Traffic Impact Study

Circle K – US-24 & Meridian El Paso County, Colorado

See comments on pages
1-39 throughout

Add "PCD File No.
CS-21-003"

FIGURE 13

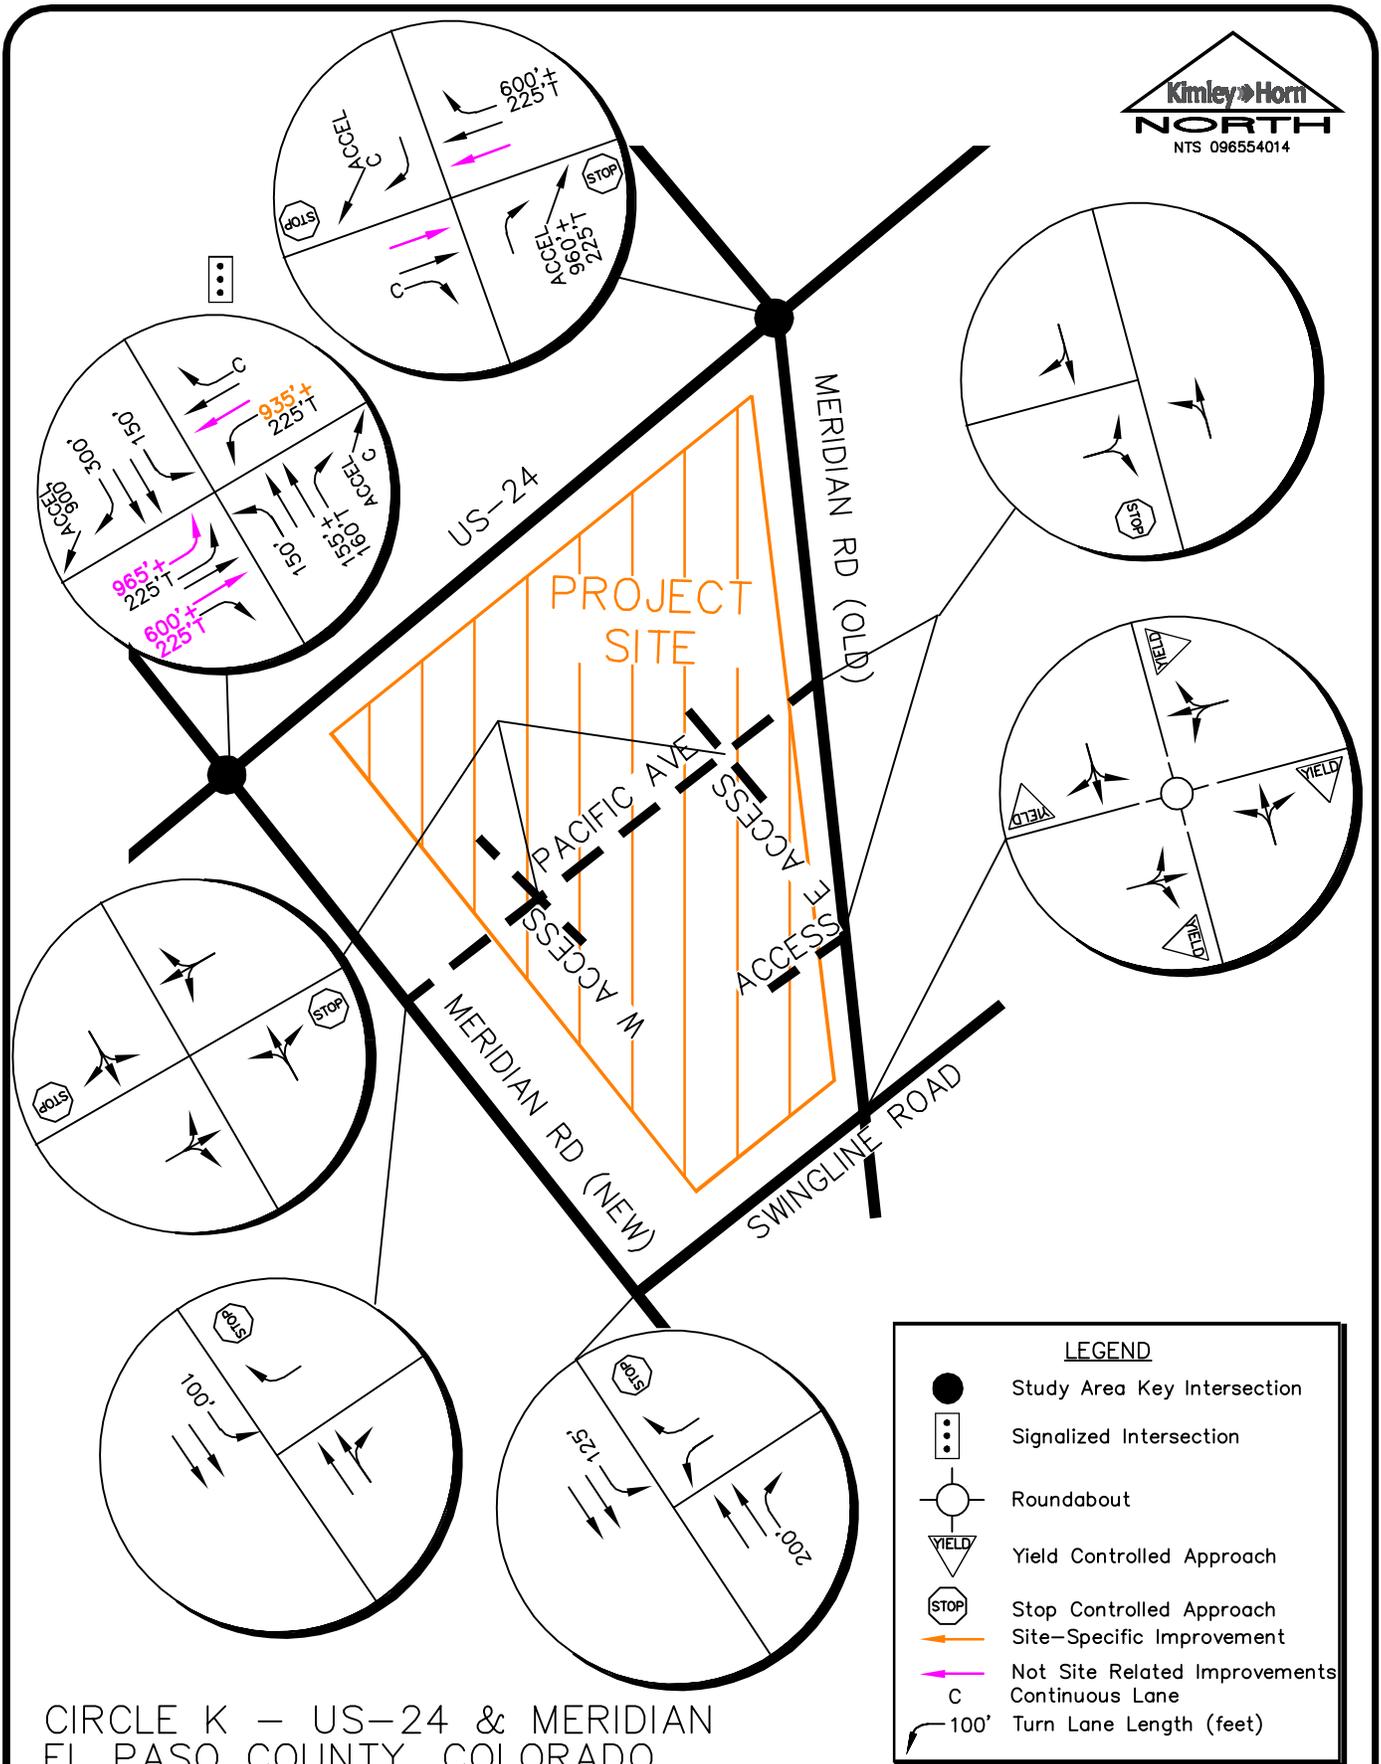
Update project site
 FIG 8-13 onward
